RE: South Academy Business Center
Response Letter

Please see our response to the comments received on January 23 and January 30.

Grading and Erosion Control Plan

DRAINAGE, GRADING & EROSION CONTROL COVER

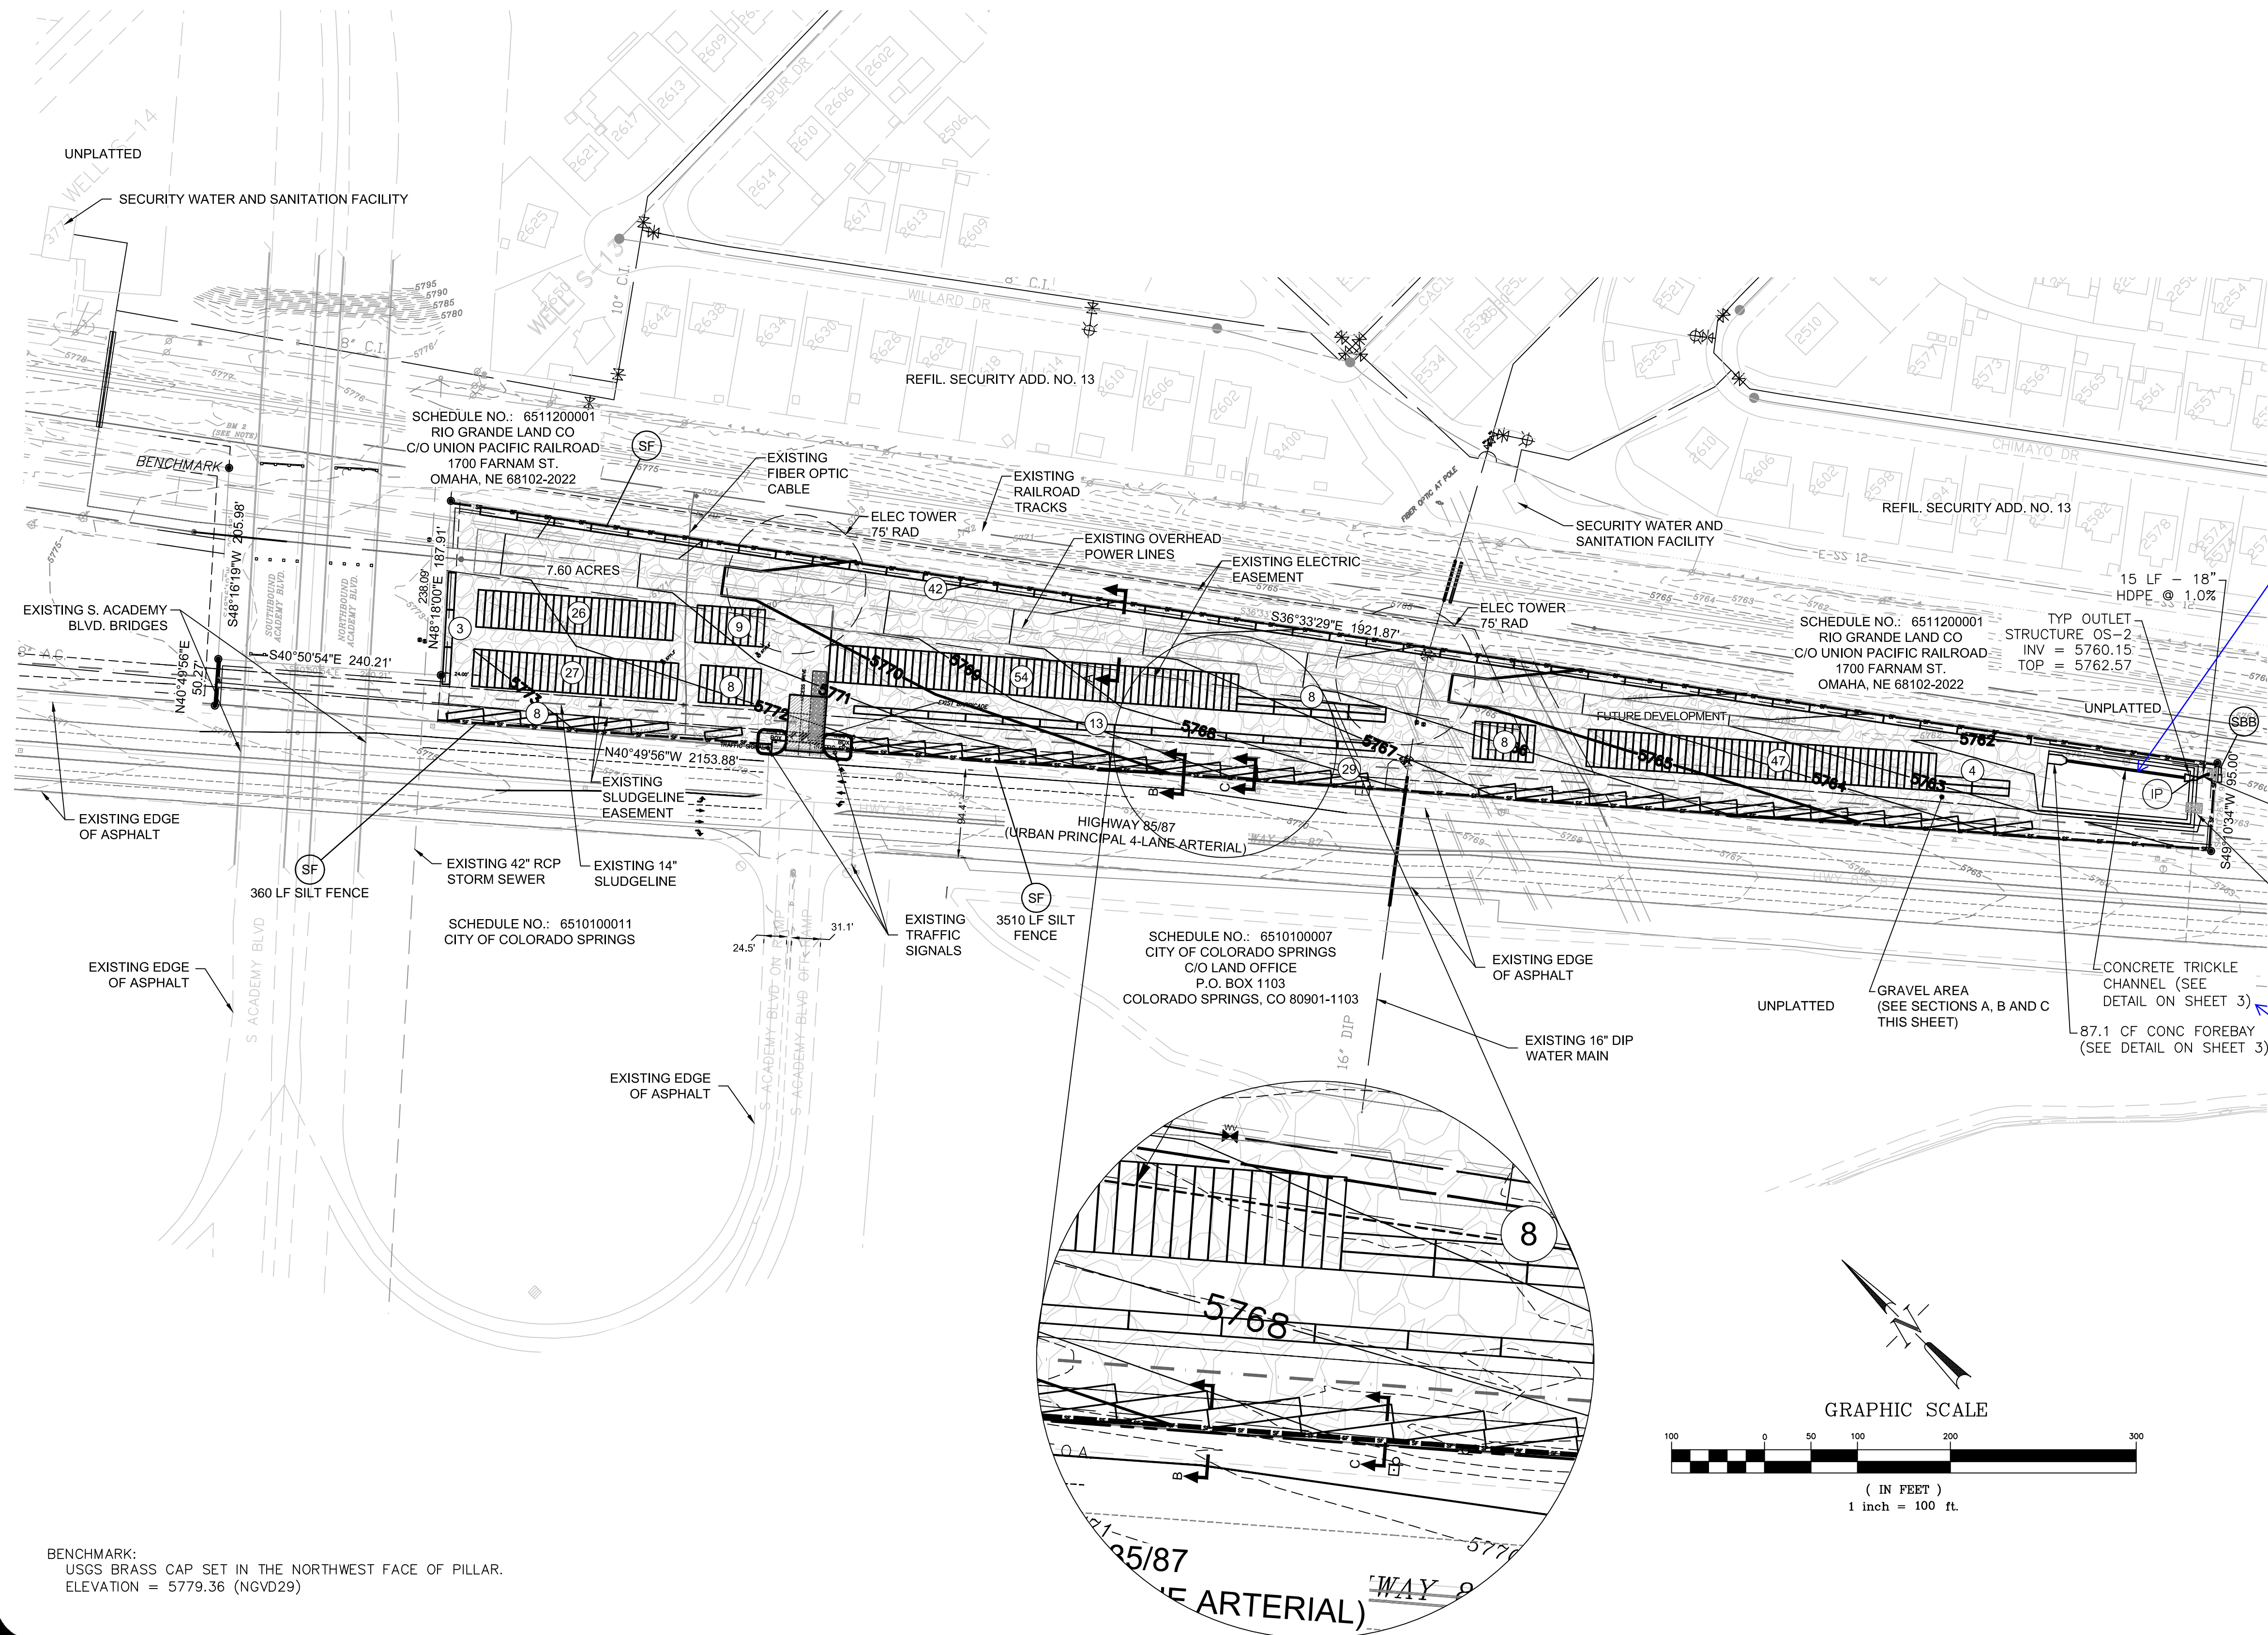
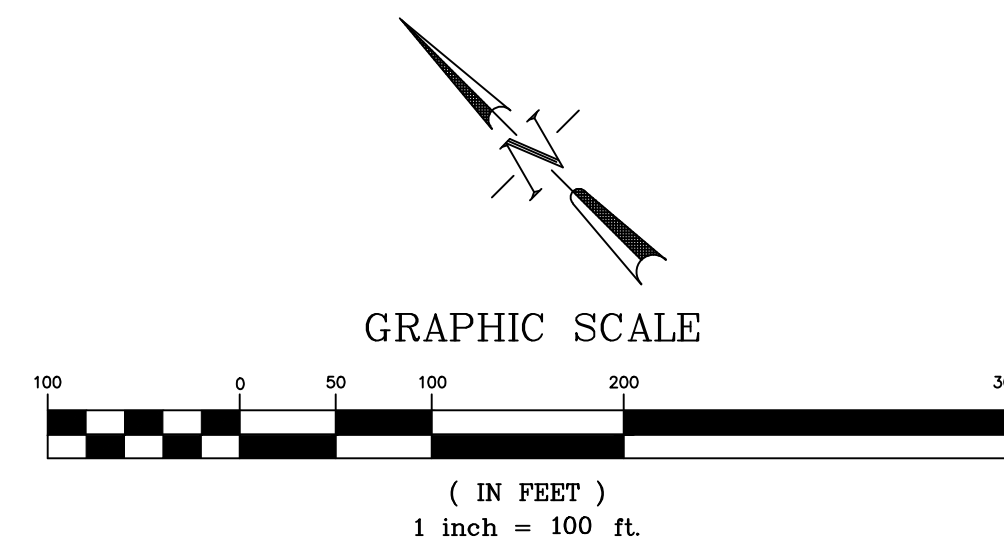
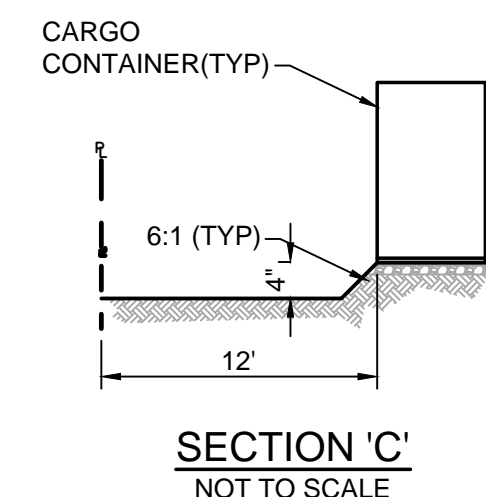
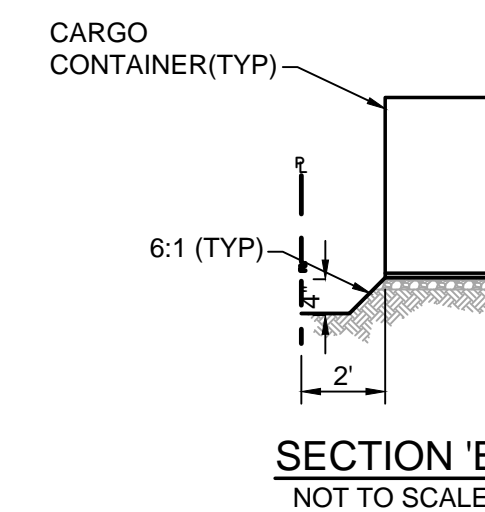
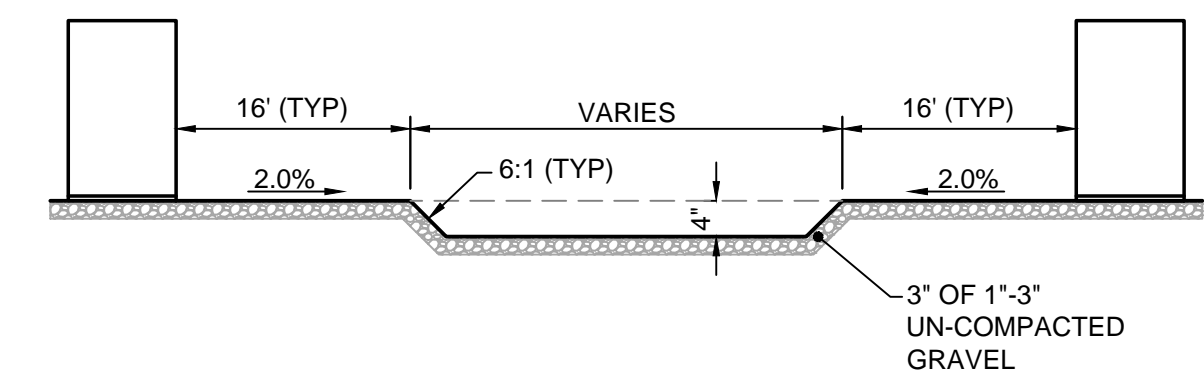
- Financial assurances have been updated.
- A deviation request is being submitted for having the temporary storage containers within the 7' rear easement. There is no proposed front drainage and utility easement.
- CSU has been contacted and will allow the temporary containers to be placed within their easement as long as they are not located above their sludge line.

EMERGENCY SPILLWAY DETAIL SEC A-A

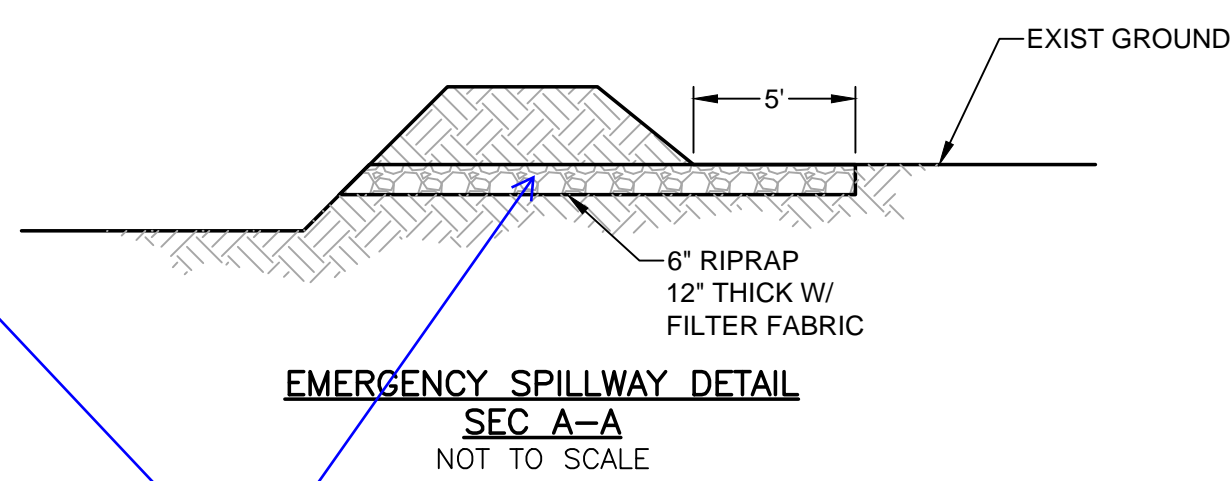
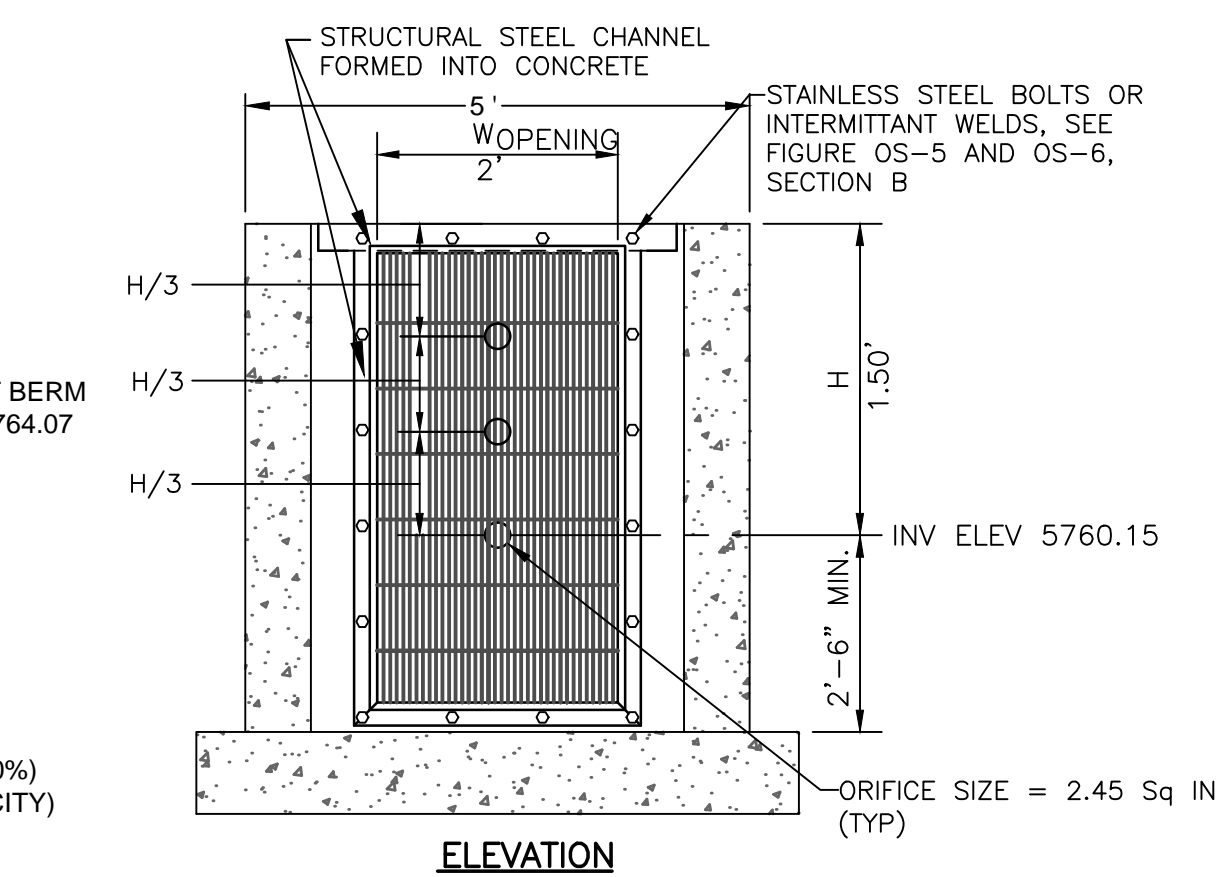
- Flows from OS1 currently flow into the railroad ditch east of the project.
- 6" restrictor plate detailed on the GEC plan.
- 8' spillway width shown on the GEC plan.
